DEVELOPMENT REVIEW BOARD

Project Number: PR-2022-007588

Project Name: New Mexico Cancer Center

Request: Amendment to Site Plan – DRB

A7 SOUTH ELEVATION
1/8" = 1'-0"

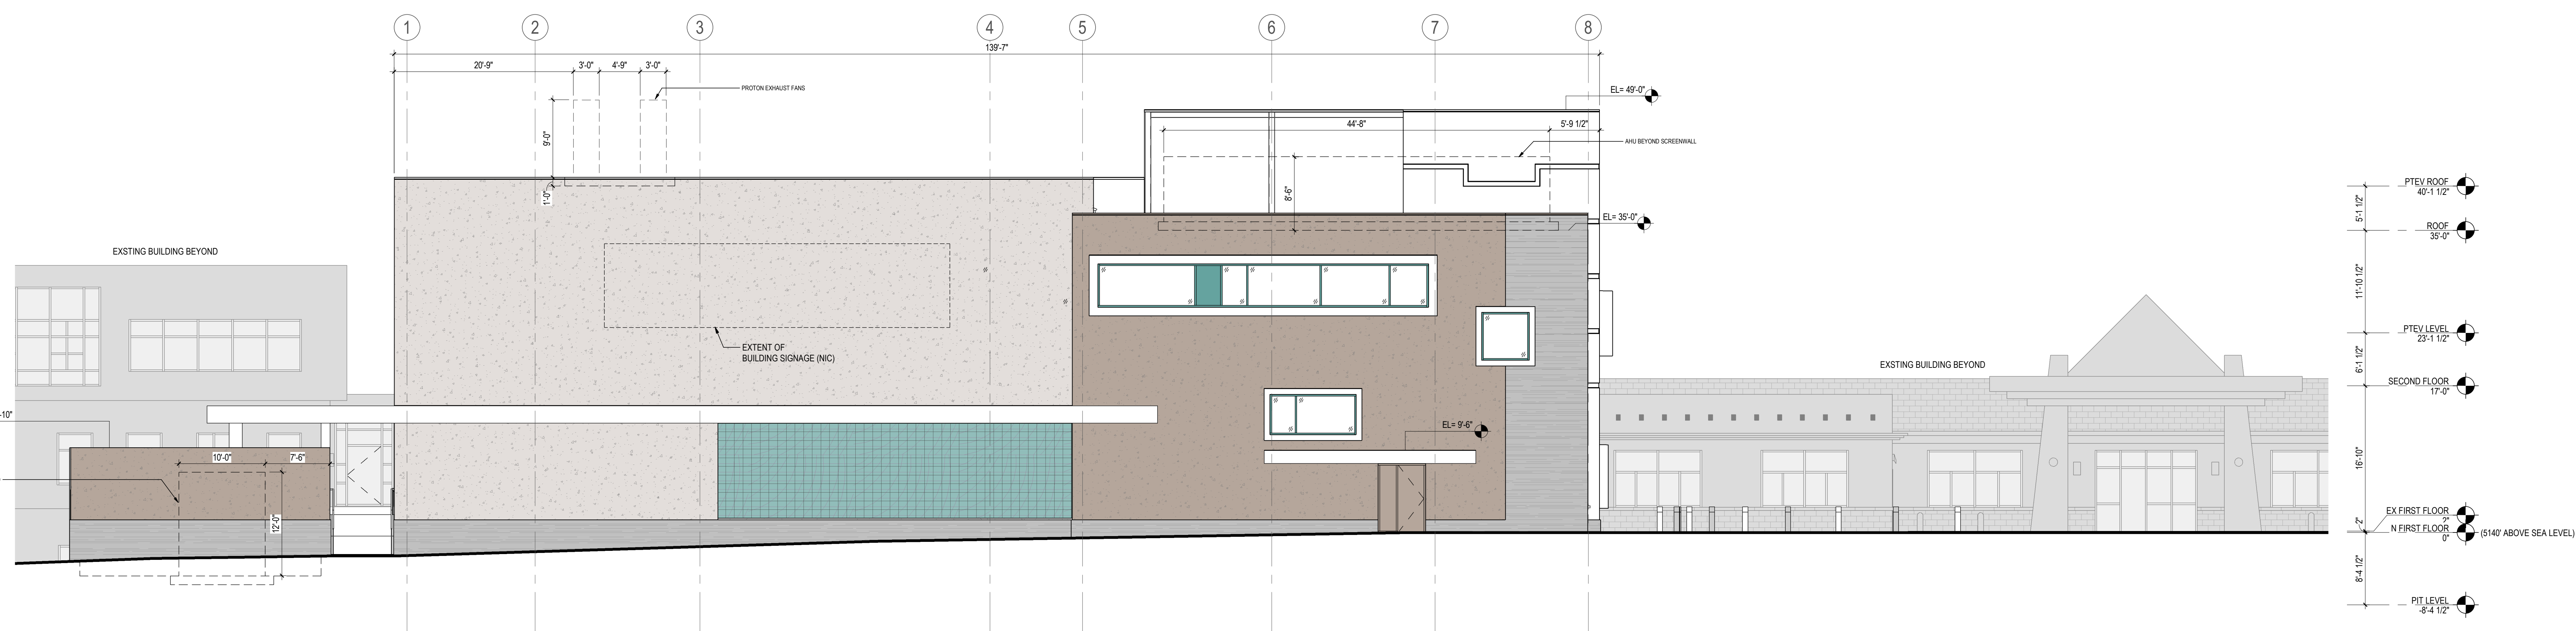
- The site is located within the Journal Center Master Plan. A letter of approval was received from the Journal Center Architectural Review Committee approving the proposed development. Staff needs more information on the façade to determine compliance.

- The applicant must provide proof how the building/façade design requirements are being met per 5-11(E) of the IDO as notes on the amended Site Plan and/or in a comment response letter.

PARKING TABULATION

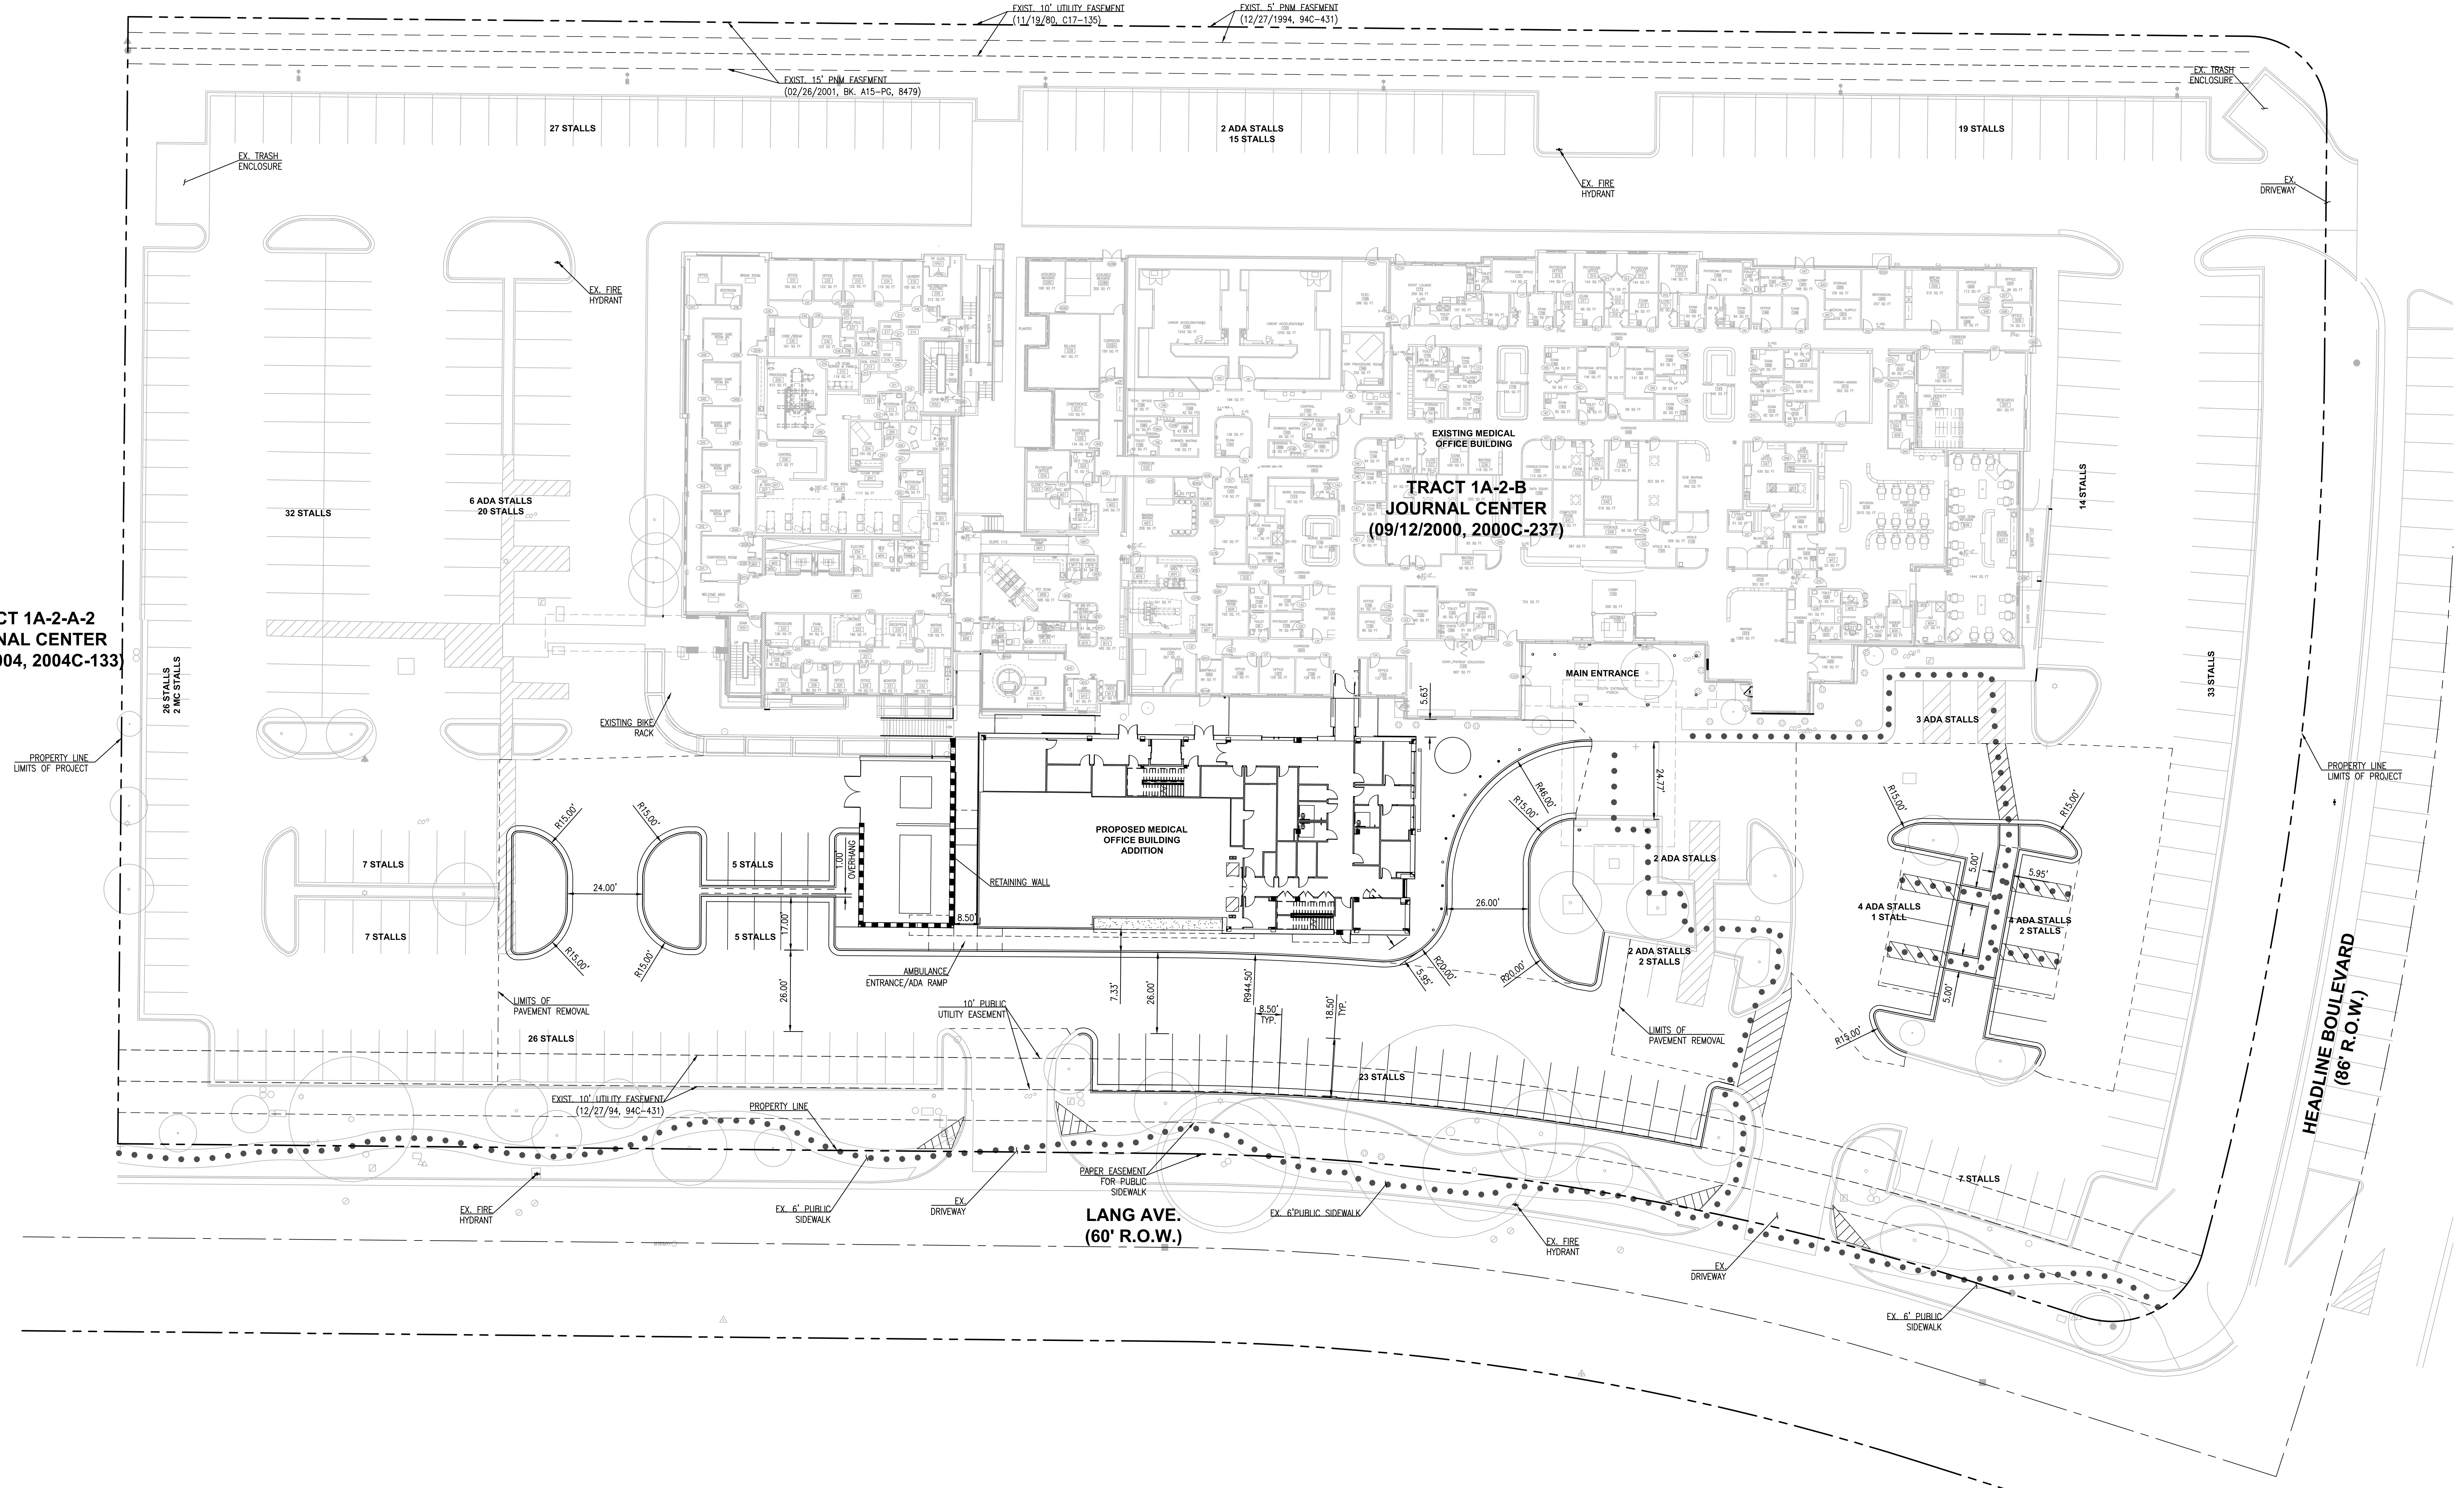
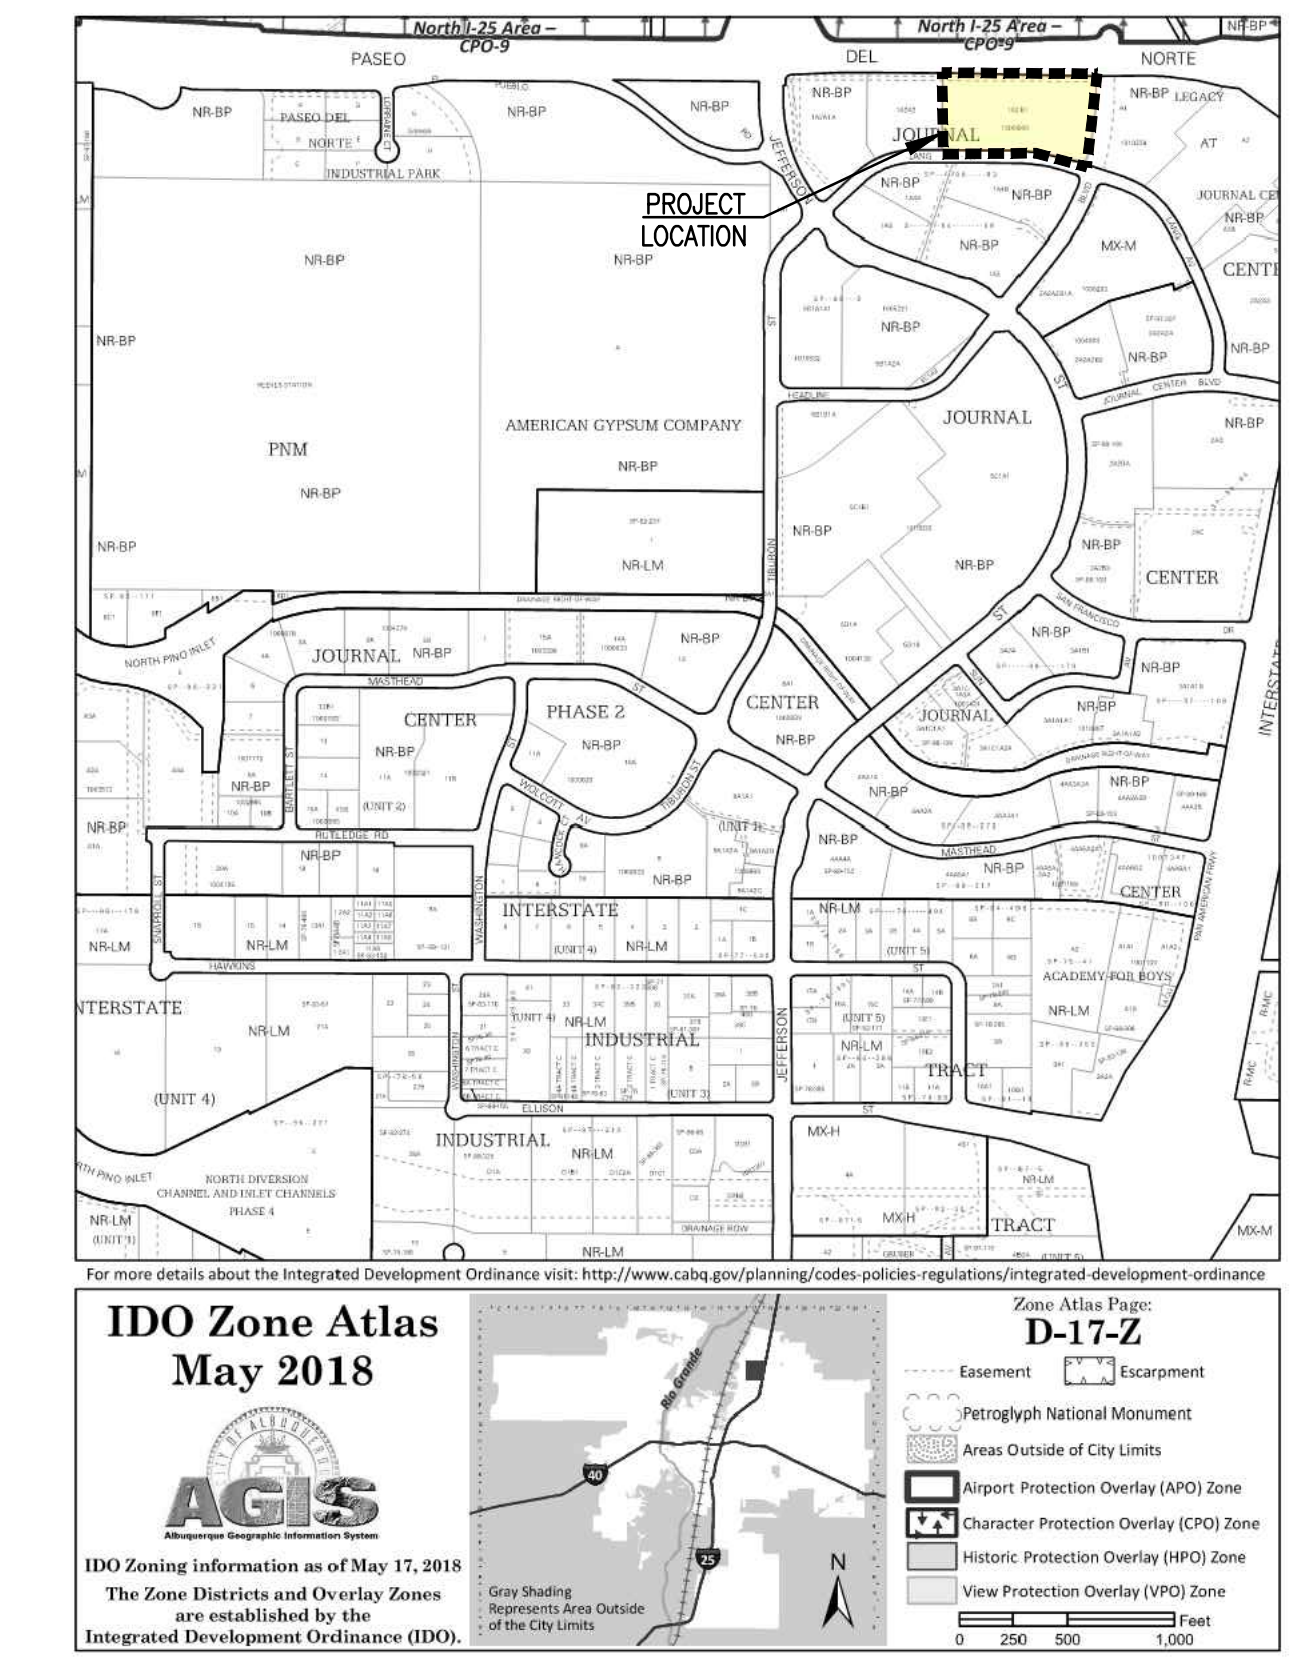
- The Parking Tabulation section of the Site Plan notes that the parking requirements for the site are based on the previously approved site plan plus the addition at current parking rates. The overall indication is that there is potentially a parking shortage per IDO requirements. Staff has talked to the applicant about sections of the IDO where parking reductions could apply and awaits a resubmittal on parking for the site.

- The Parking Tabulation section of the Site Plan notes that 100 parking spaces will be provided off-site. If any off-site parking spaces will be utilized and will count toward the total of number of required parking spaces, a recorded Shared Parking Agreement will be required for those parking spaces and must be submitted prior to the approval of this Major Site Plan Amendment – DRB.

- The number of bicycle parking spaces which are required are depicted in the Parking Tabulation section, but the number of bicycle spaces/racks which are being provided is not depicted. That information needs to be added to the Site Plan.

- Detail as to how the required number of motorcycle spaces (6 spaces) was calculated needs to be provided in the Parking Tabulation section.
- The Landscape Plan must meet the 15% net lot area landscaping requirement per 5-6(C)(2) of the IDO. Confirmation and calculations of this requirement must be provided on the Landscape Plan. (The plan sheet seems to state that the fire lane makes this requirement non-applicable, however staff is not able to confirm this per the IDO.)
